### **East Anglia One North and East Anglia Two Offshore Wind Farms**

**Planning Inspectorate Reference: EA1N – EN010077 &  
EA2 – EN010078**

**Deadline 7 – 4 March 2021**

**East Suffolk Council's Response to Deadline 7**

## East Anglia ONE North

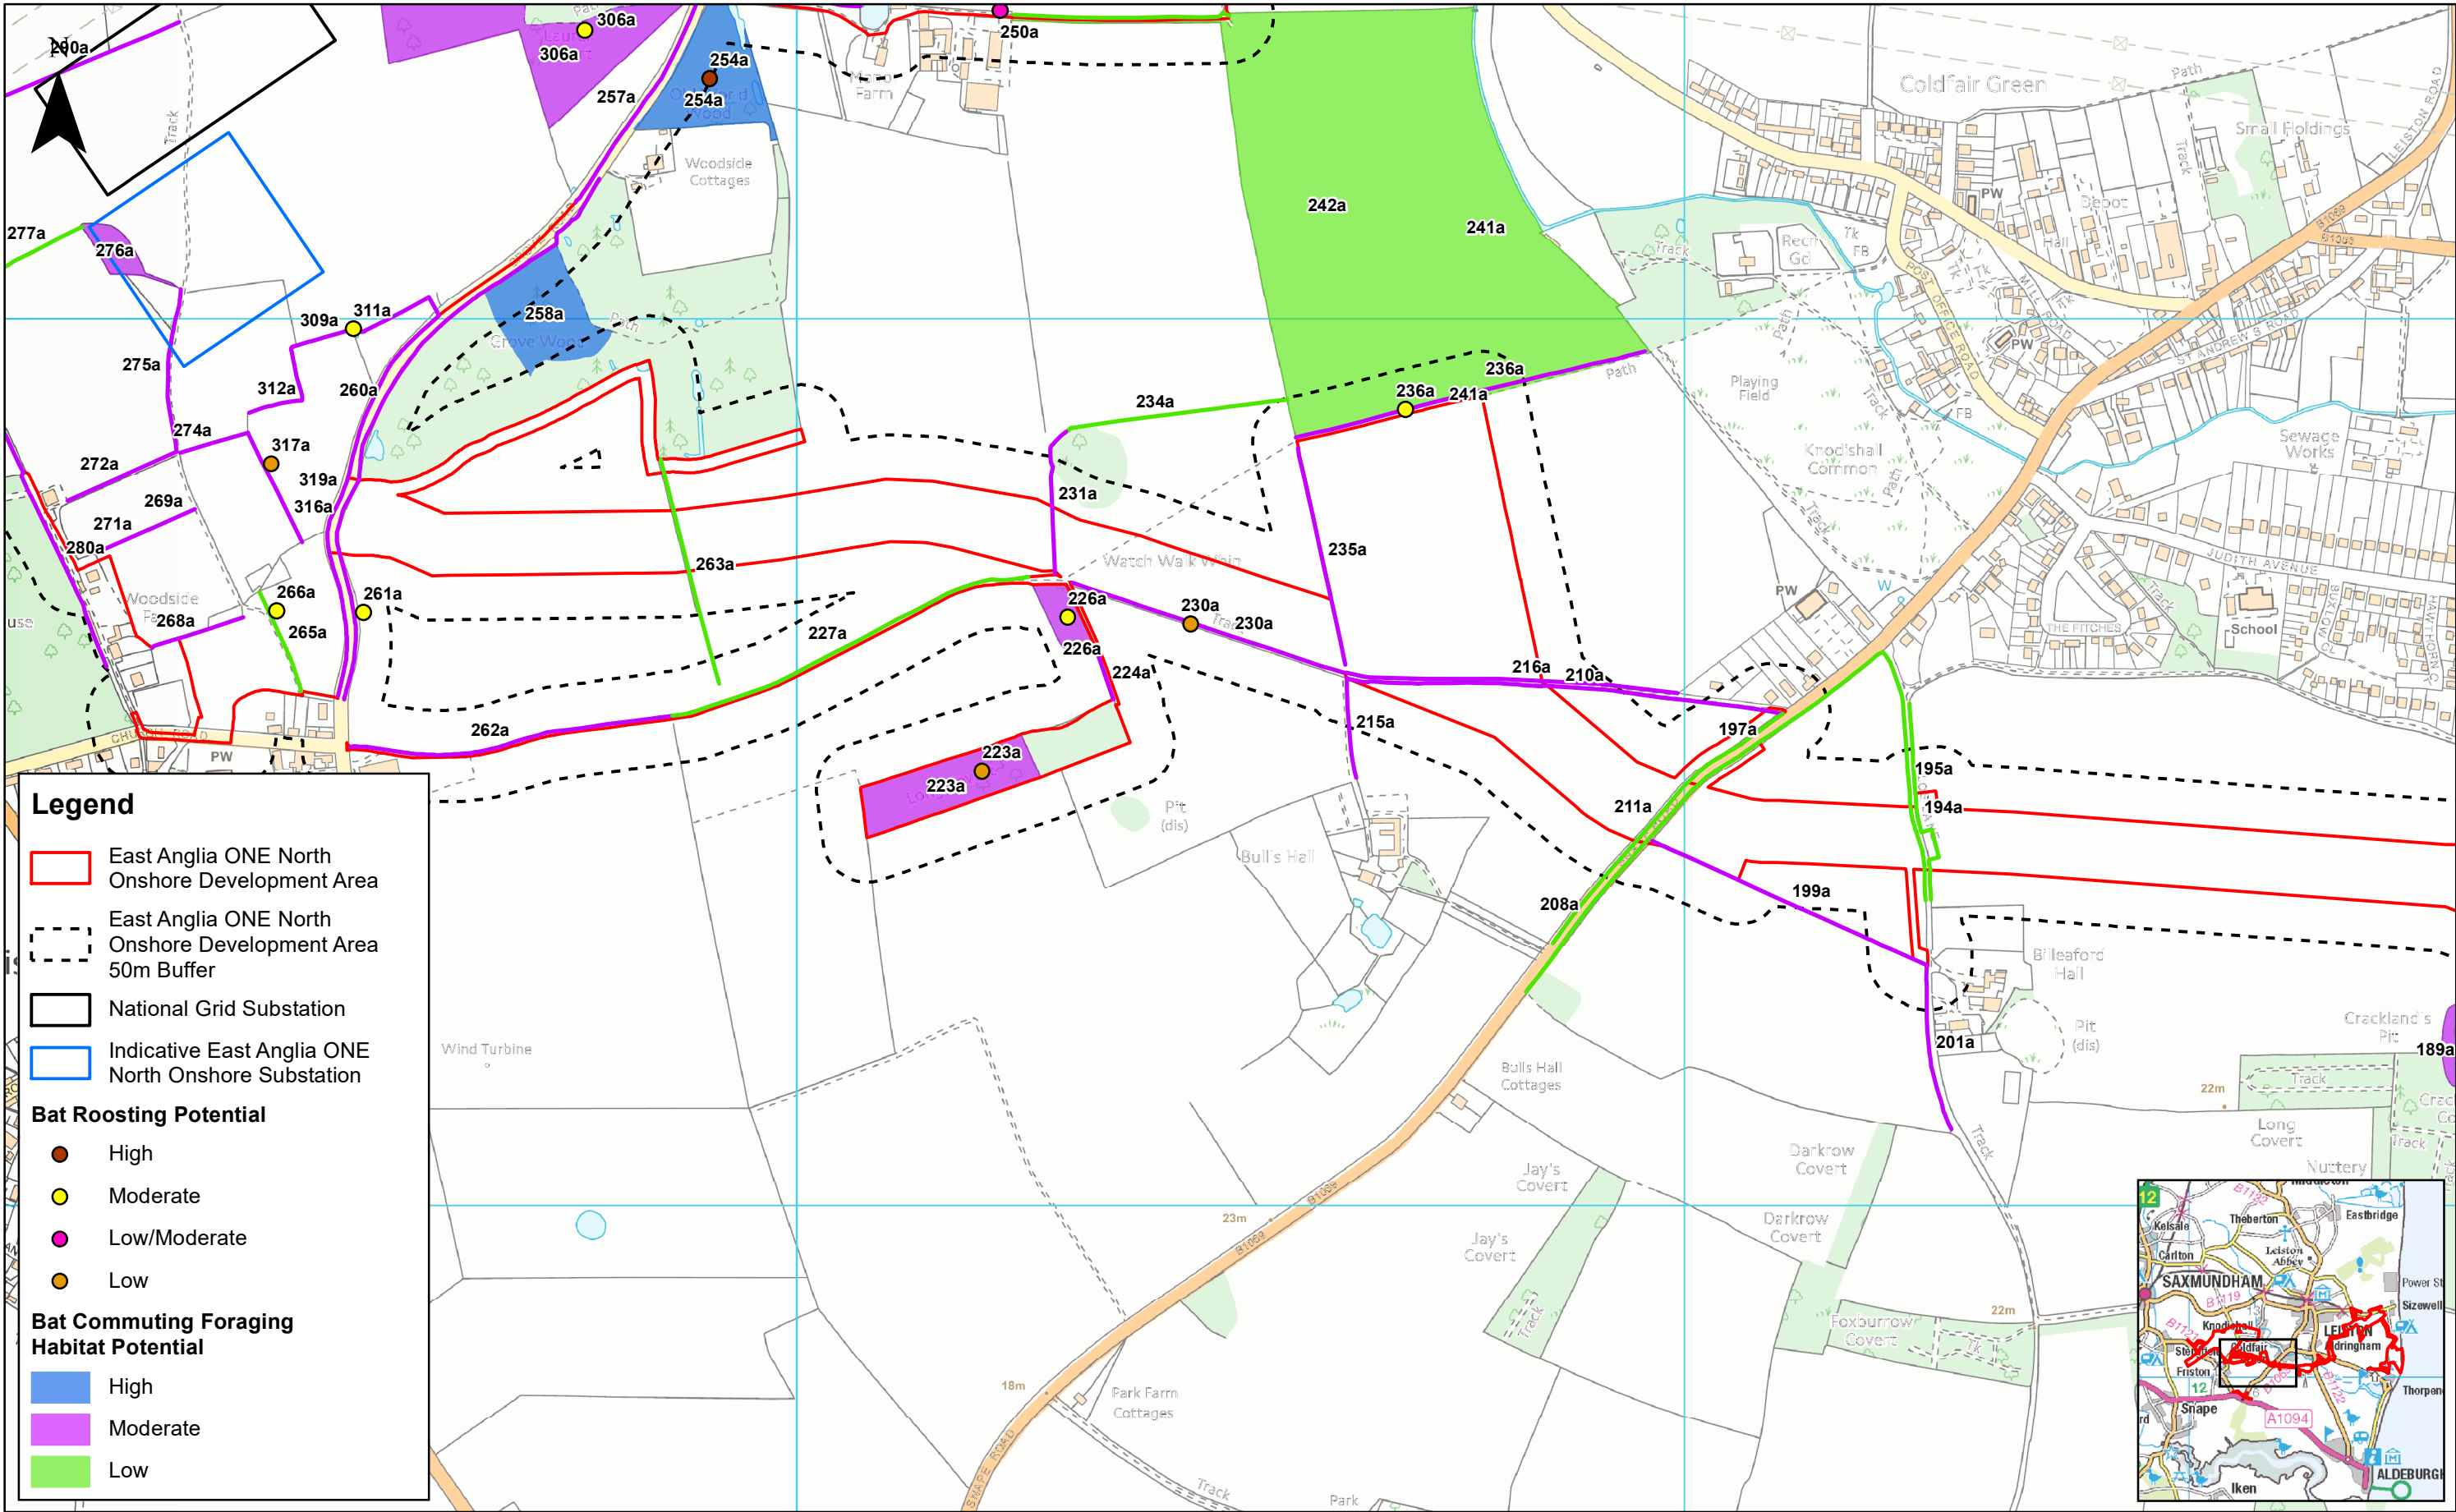
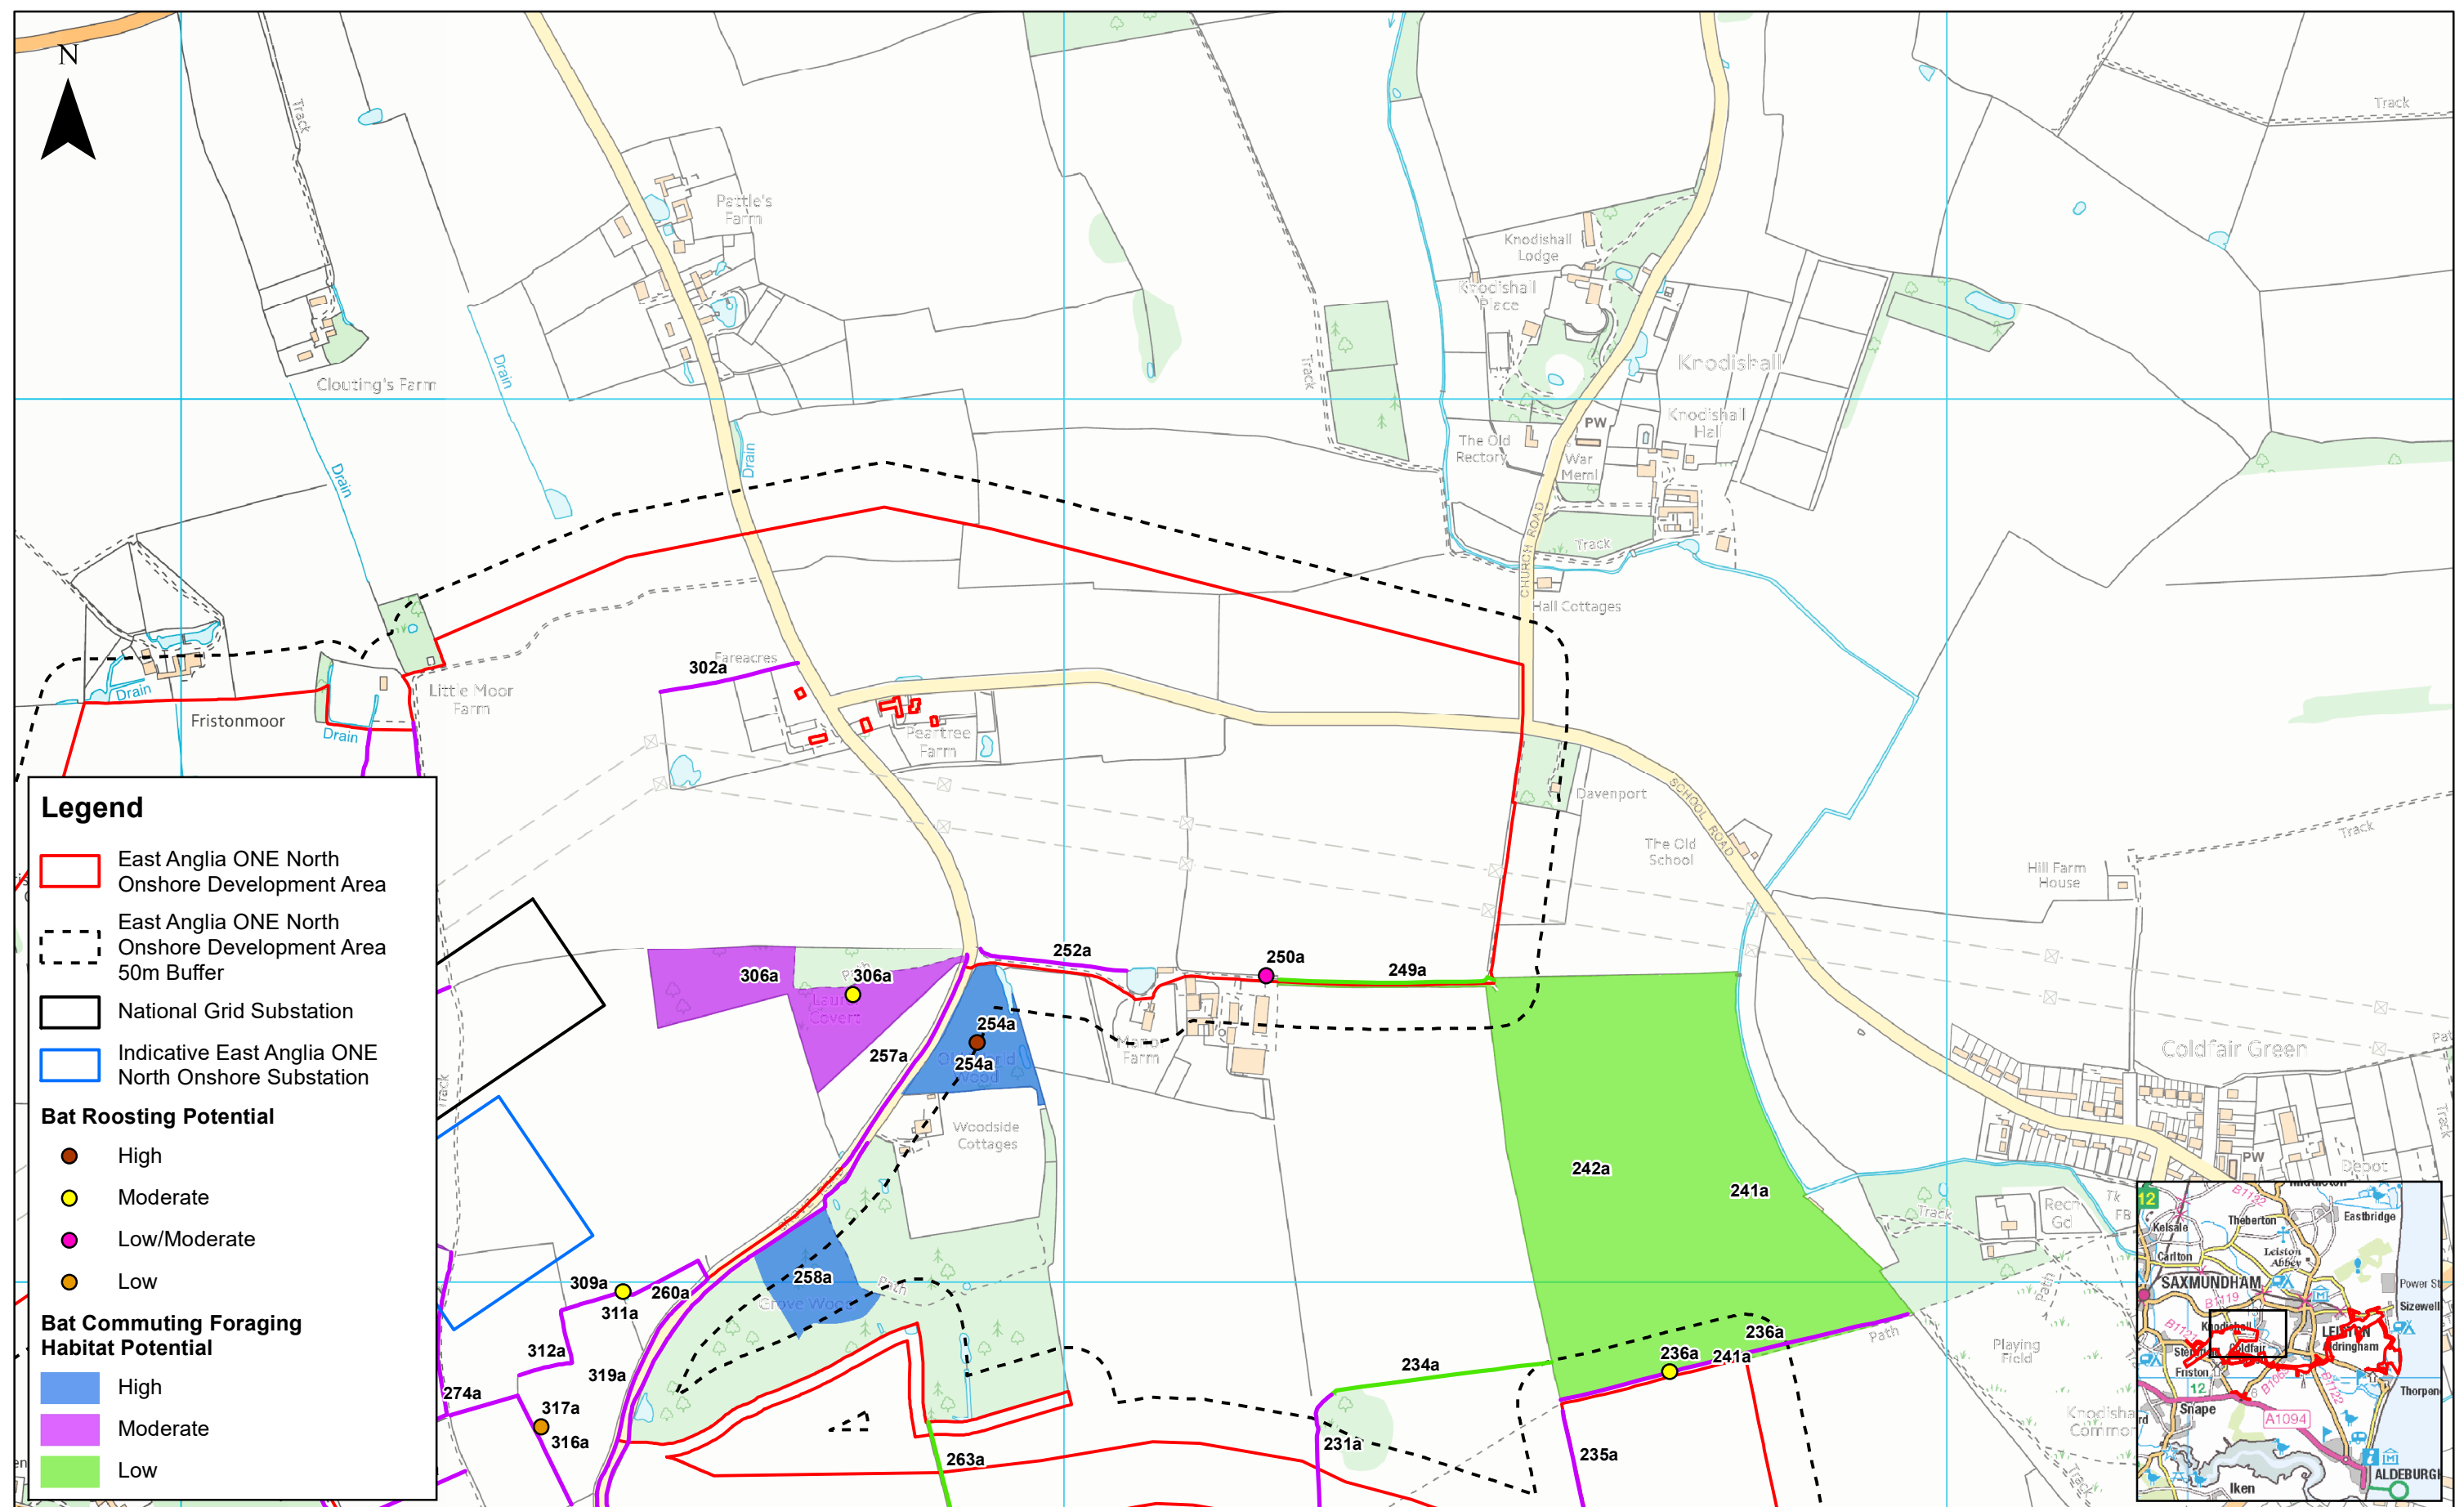
- 2.16. Bats - Whilst the Applicants' response to ESC's Deadline 5 comment (REP5-048) on this matter is noted (Section 2.3, ID1, REP6-026), the Council maintains the opinion that the absence of brown long-eared bats from the survey results is likely an under recording of this species in the area rather than a complete absence of the species. All of the bat survey techniques used (emergence/re-entry, activity transects and static bat detector) rely primarily on acoustic recording and the nature of brown long-eared bat behaviour (particularly the absence of echolocating or very quiet echolocating) is an acknowledged limitation of this type of surveying. Further comment on this matter was made at Issue Specific Hearing 7 (ISH7, REP6-075).

2.17. We also note the comment in the relation to maternity bat roosts being present at other substation sites (Section 2.3, ID2, REP6-026). As set out in our Deadline 5 response (REP5-048), and acknowledged in the Applicants' comments on this matter, different bats are affected by noise to different degrees and the presence of a maternity colony of one species in such a location does not mean that all other species have not been affected. Further information on the species present roosting within existing substations would have been beneficial.
